Your Ref: OWPC22311
Our Ref: R/72/19/PL 02-04-2019
Please ask for:
Mrs A Gardner

Demolition of existing garage & store on existing dwelling & construction of 2 new dwellings in rear garden.

6 Manor Road Rustington

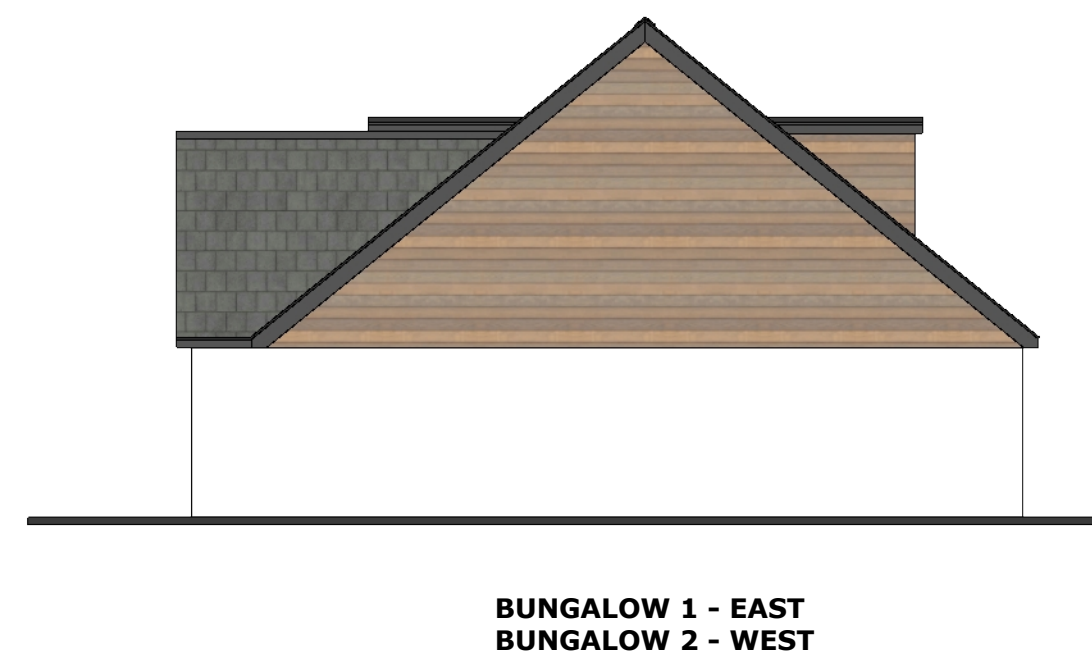
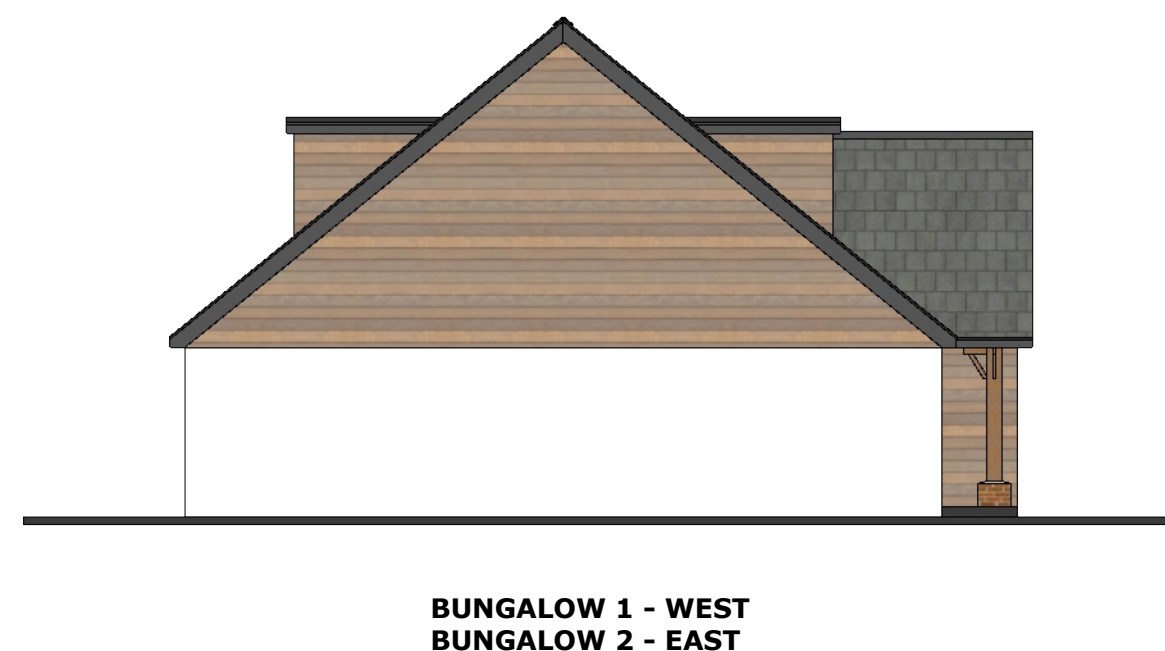
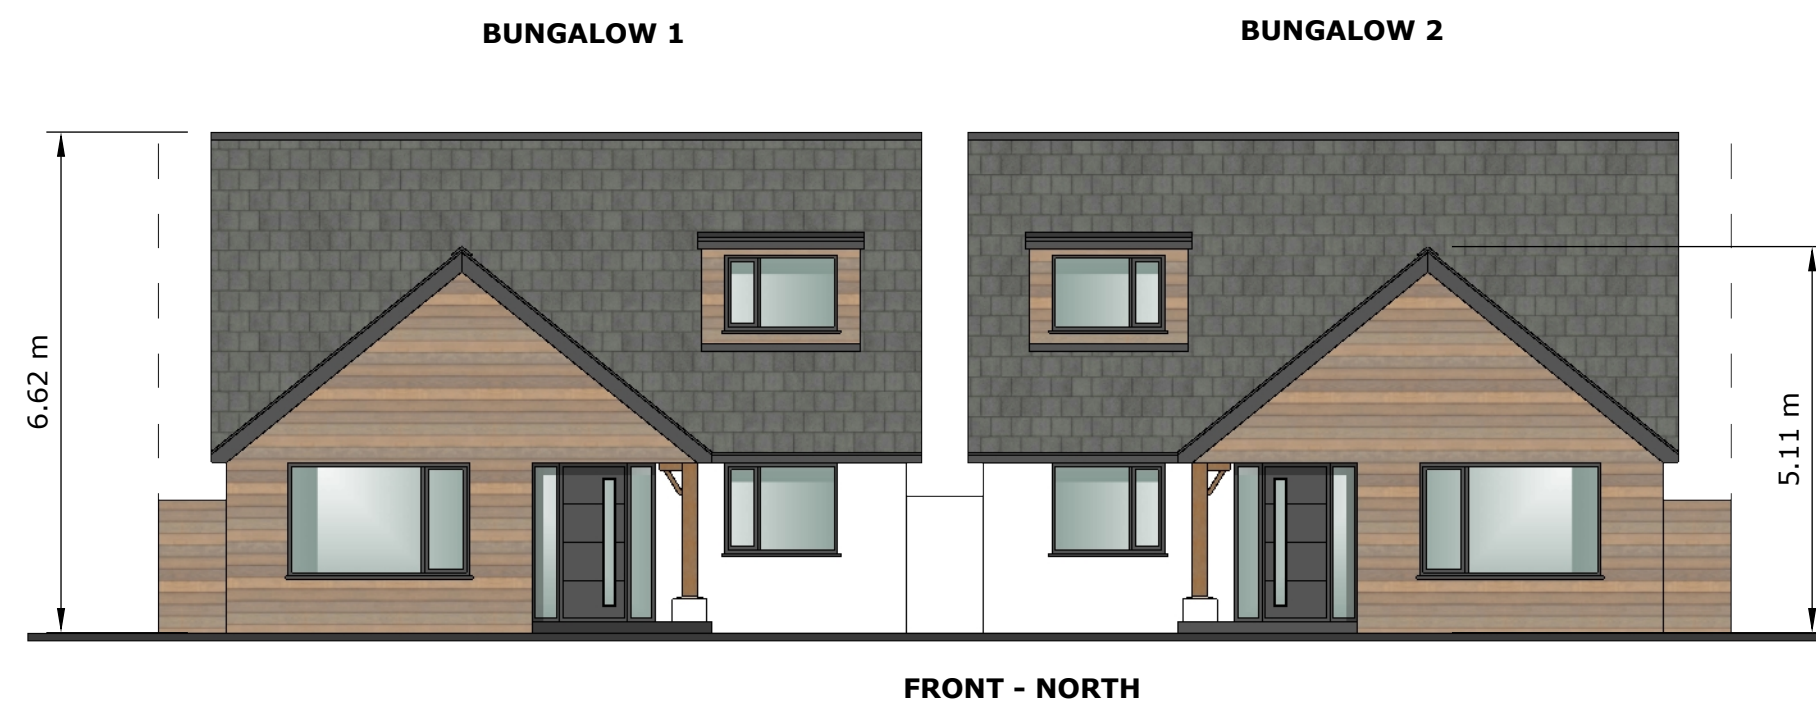
- 1. The design statement shows a ridge height of 6.2m but the elevation drawing shows a height of 6.62m a difference of 0.42m.*
- 2. The site drawing roof plan shows barn hips at opposite ends of each property, however the elevation drawing shows full height gable ends and no hips.*
- 3. The proposed site plan shows a dimension of 1.92m between our property and the nearest chalet bungalow and a figure of 0.9m to the boundary, which leaves a figure of 1.02m from our property to the boundary. The actual dimension from our property to the centre line of the boundary is 0.87m approx. Is the figure of 1.92m between properties correct.*
- 4. On the first floor plan in Bedroom 2 a side window is shown, however the elevations fail to show a window.*

We are concerned by the height of the new chalet bungalows and with no street scene or elevation showing the relationship between the proposed chalet bungalows and the

existing bungalows it is not being made clear visually how the development will actually look and fit into its surroundings.

The ridge height of our bungalow is 4.95m, our eaves height is 2.21m. the front to back measurement of the bungalow with pitched roof above is 7.98m and it has a roof pitch of 30 degrees.

I have attached in my email to you two A4 1/50 scale drawings showing a part front elevation and side elevation showing how our existing bungalow and the new chalet bungalow will likely look next to each other as at present the ridge height of the proposed chalet bungalows will be approx. 1.67m higher than the ridge height of our bungalow.

Even the lower front projection of the proposed chalet bungalows, which has a ridge height of 5.11m is higher than the existing bungalows.

DRAWING: PROPOSED NEW DWELLINGS - PLANS **SCALE:** 1:50 @ A2 **DATE:** 29/03/2019 **DRAWING No:** DS/6MANOR/04

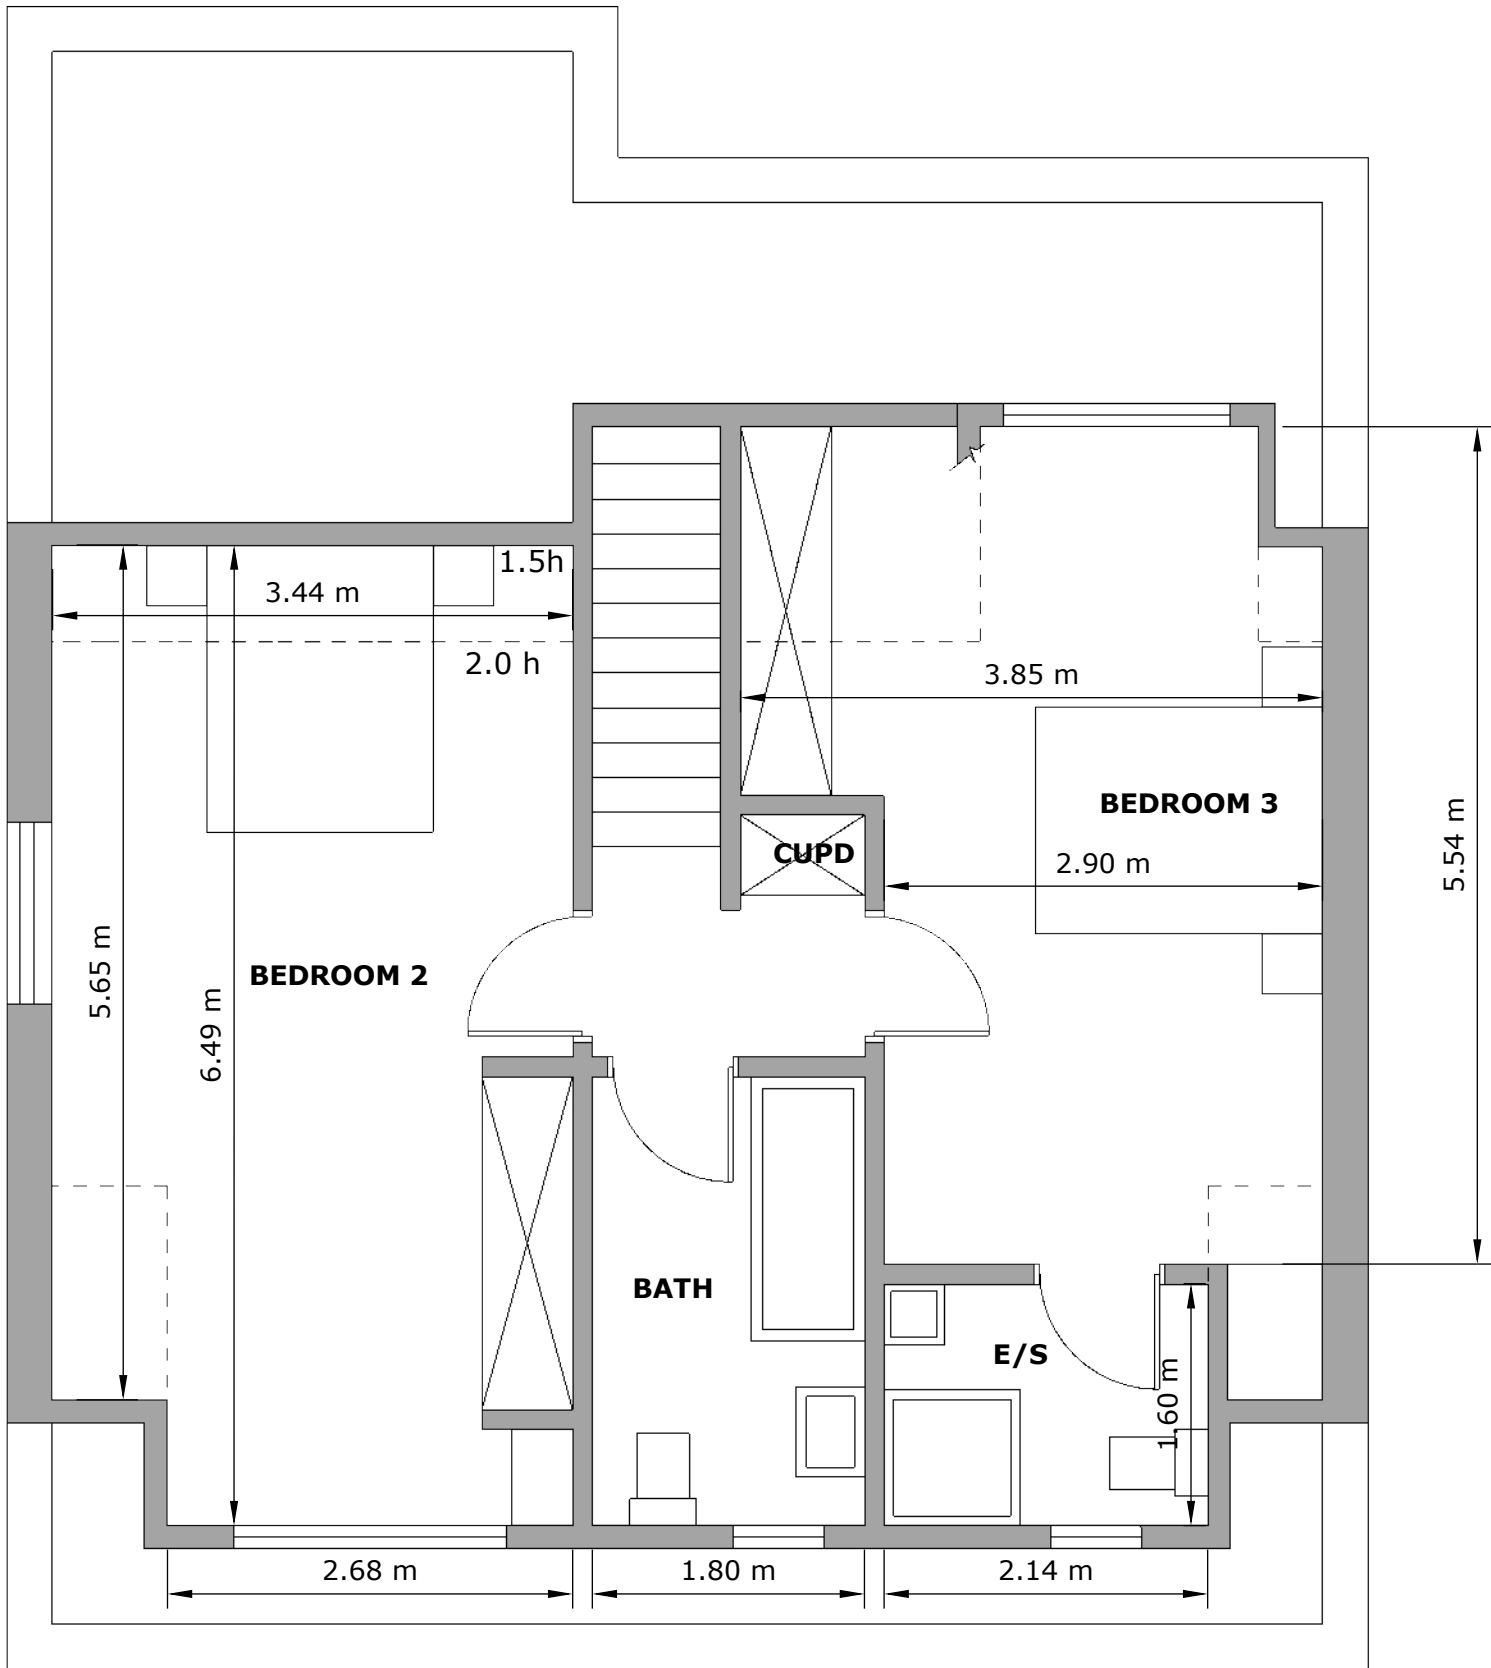
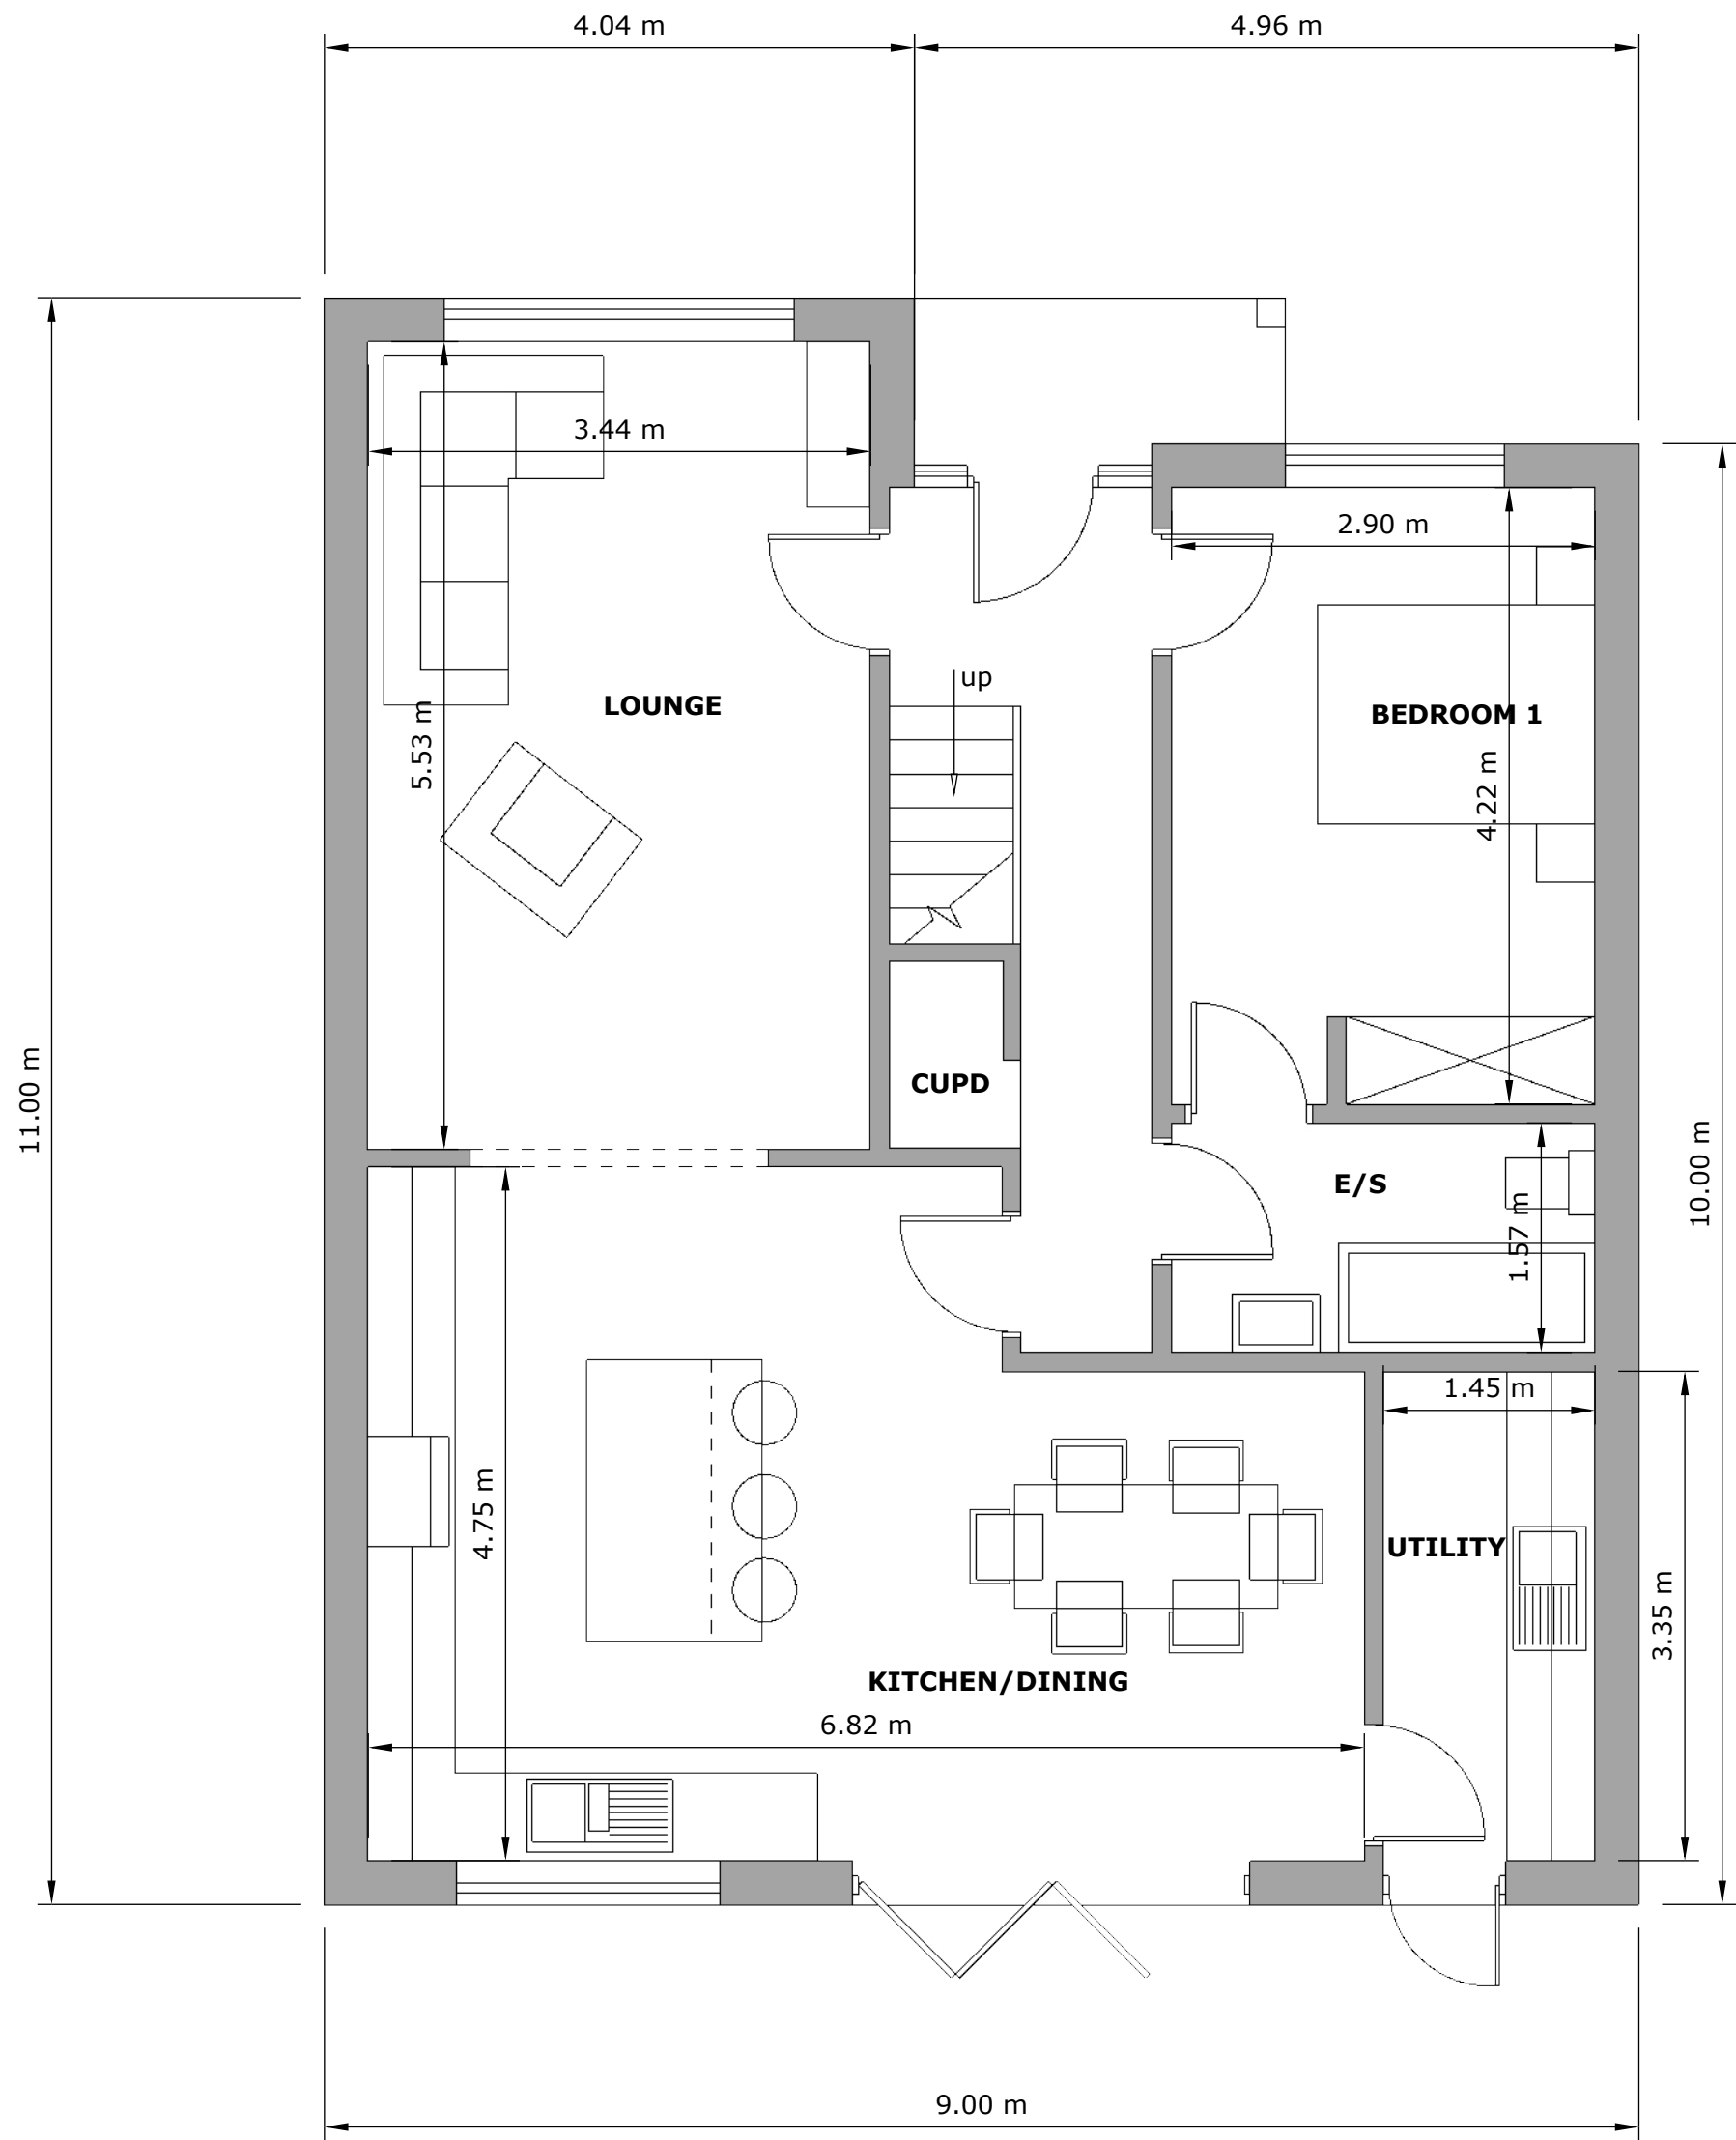
We have concerns with the close positioning of the proposals to our bungalow and being overlooked. Provision of obscure glass to the two small windows closest to us, which we believe are bathrooms, would be welcomed. The front of the new chalet bungalows will sit forward from the front of the main build line of the bungalows 2, 3 and 4 by just over 3.0m which we feel is excessive.
